Rezoning Transportation Analysis

Petition Number: 2021-092

Date	Description
06-01-2021	First Review (KP)
08-23-2021	Second Review (KP)
10-22-2021	Third Review (KP)
11-22-2021	Fourth Review (KP)

SECTION L-L EAST MOREHEAD ST

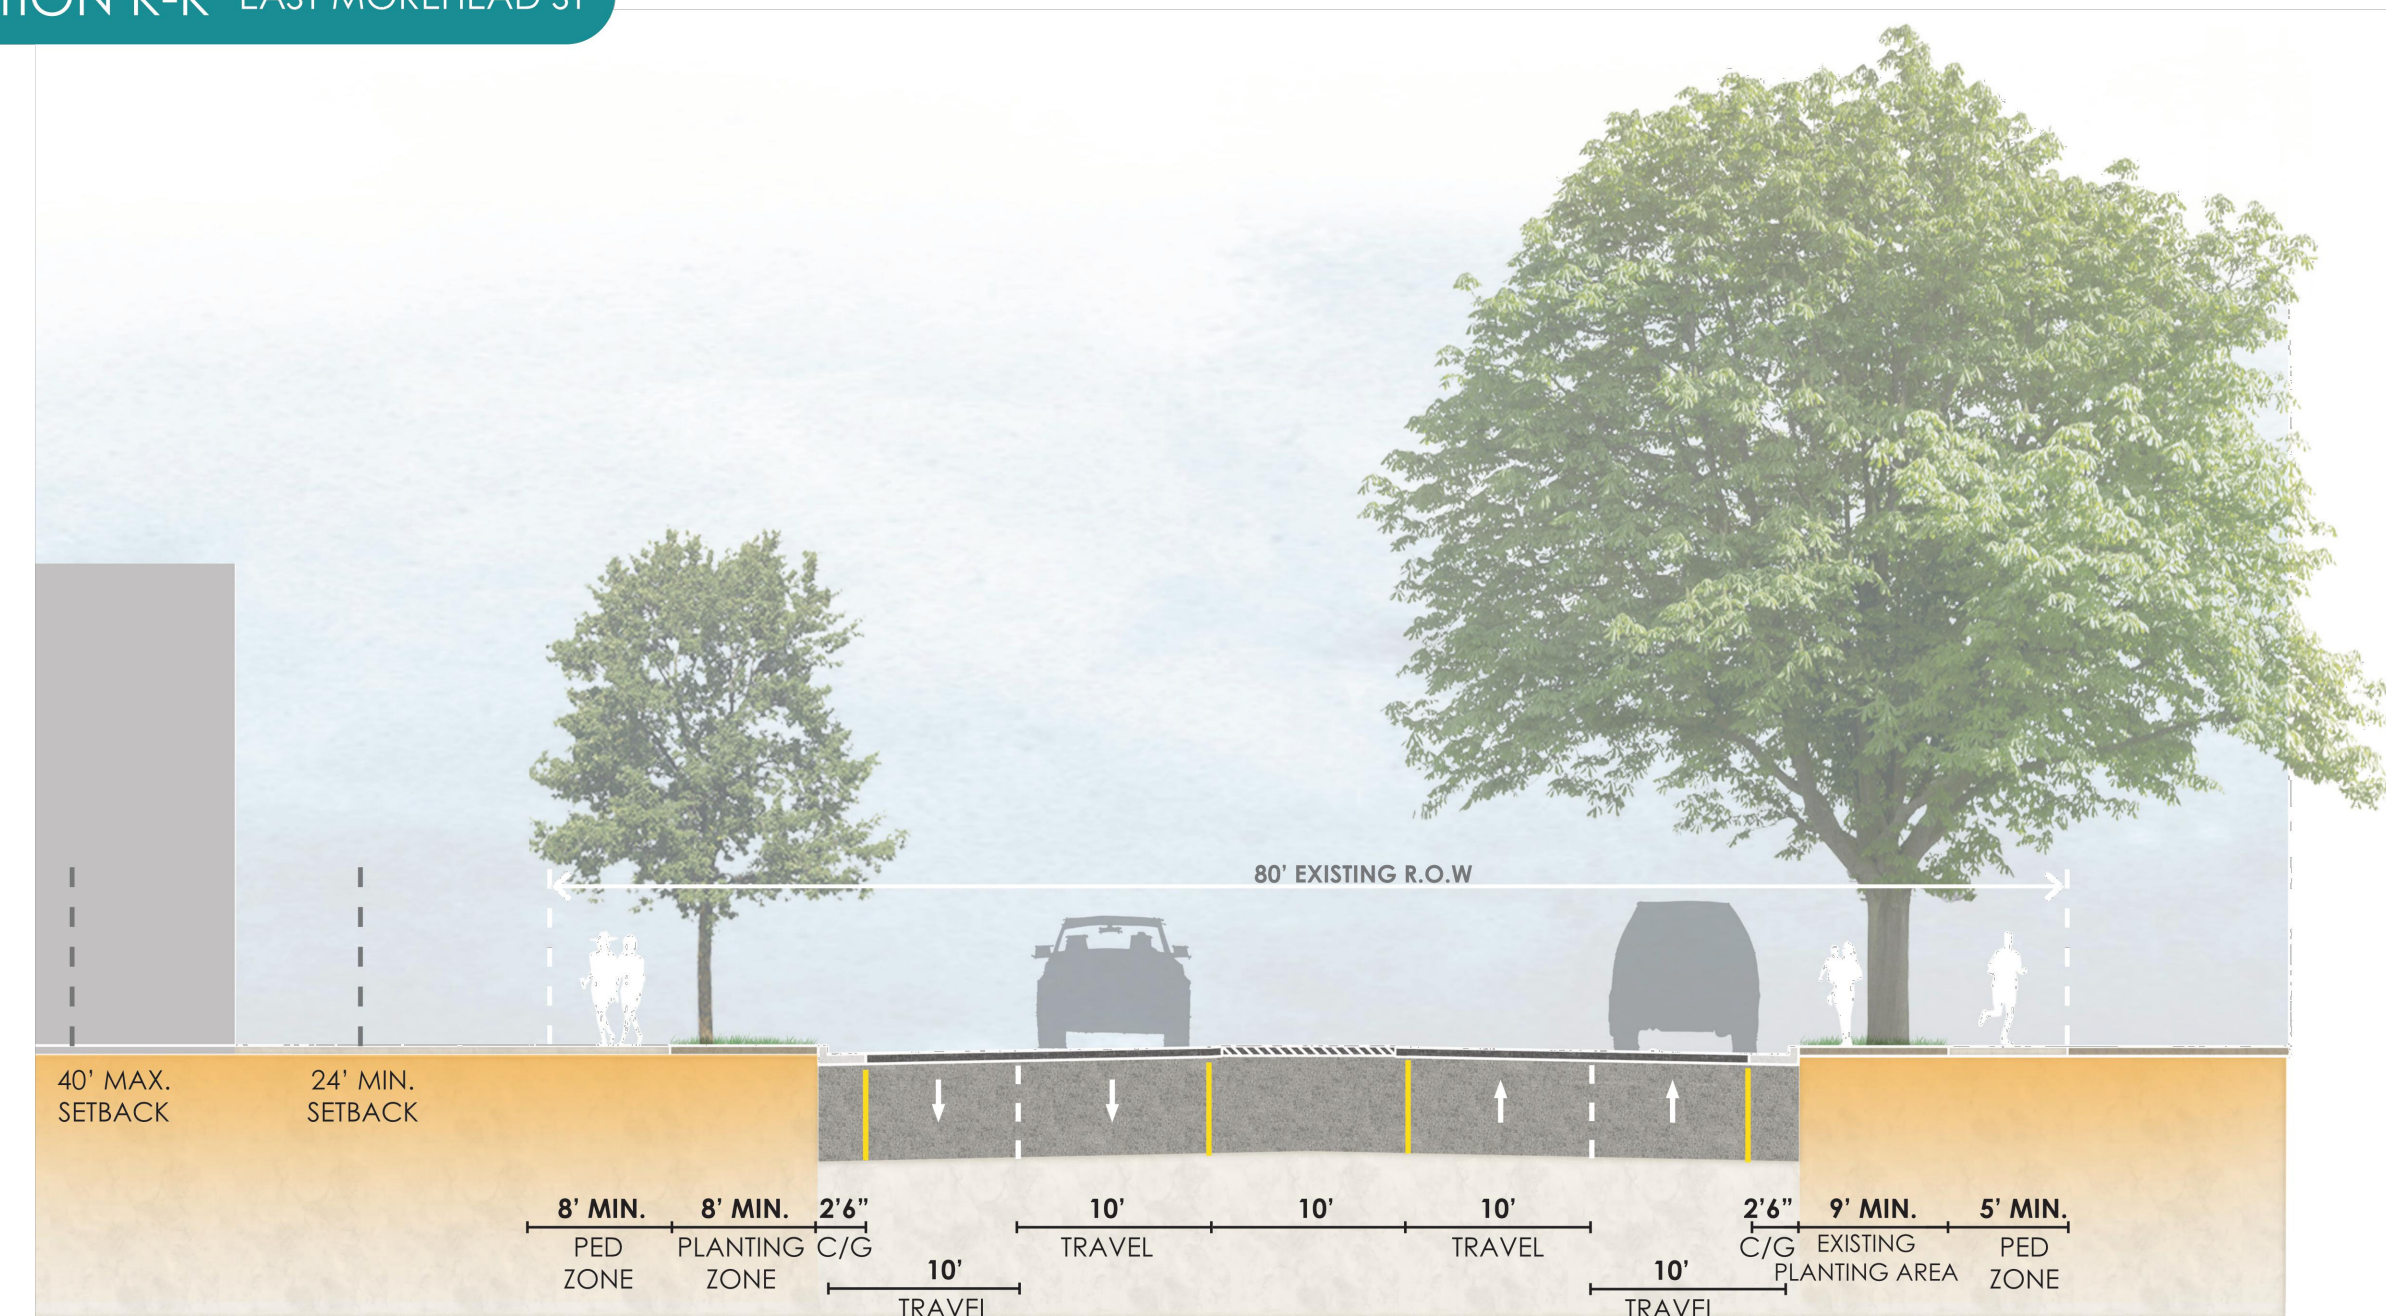
1. **Curb line:** The proposed zoning district has a setback measured from back of the existing or proposed future curb line. Revise Sheet RZ-1.1 by adding the curb line dimensions to the cross sections provided. Please note: The following curb line dimensions proposed are conceptual and may be altered as coordination with CDOT throughout the rezoning process ensues.

- a. ~~**Morehead Street:**~~ The location of curb and gutter will be moved and located 38 feet from the existing centerline to the back of curb. ~~(Revise Site Plan Dated: 10.12.21)~~ Update to comply with Chapter 20 sidewalk and planting strip requirements.

The proposed and existing back of curb location on Morehead Street must be labeled dimensioned from the existing centerline.

3. **Right of way and Other Infrastructure Dimensions:** Revise Rezoning Sheet RZ-1.1 to include detailed dimensions for each infrastructure item, and the total right of way for the cross sections shown. Refer to the USDG Cross sections and on street parking details, located within the Charlotte Land Development Standards Manual, to determine the appropriate widths associated with each infrastructure item and the cross sections' total widths. Revise the site plan sheets by clearly labeling each public and private street section as well as each access point. Labeling each street section and access point will allow for thorough comments throughout the rezoning and permitting process. CDOT prefers the separated cycle track and sidewalk for McDowell Street (cross sections A-A and B-B). Please note: The following right of way dimensions proposed are conceptual and may be altered as coordination with CDOT throughout the rezoning process ensues:

- a. ~~**Morehead Street: (10/21/2021 Site Plan)**~~ – 56 feet of right of way dedication measured from the existing road centerline.
- b. ~~**McDowell Street:**~~ 110 feet of total right of way dedication, 55 feet measured from the existing road centerline to each right of way line.

The proposed and existing Morehead Street right of way dedication must be labeled dimensioned from the existing centerline. ~~**Outstanding comment (10/21/2021 Site Plan)**~~ – Revise the site plan conditional notes and legends that all new streets shall be determined as public or private during permitting. Revise cycle track along McDowell Street to include a sidewalk utility easement, where appropriate.
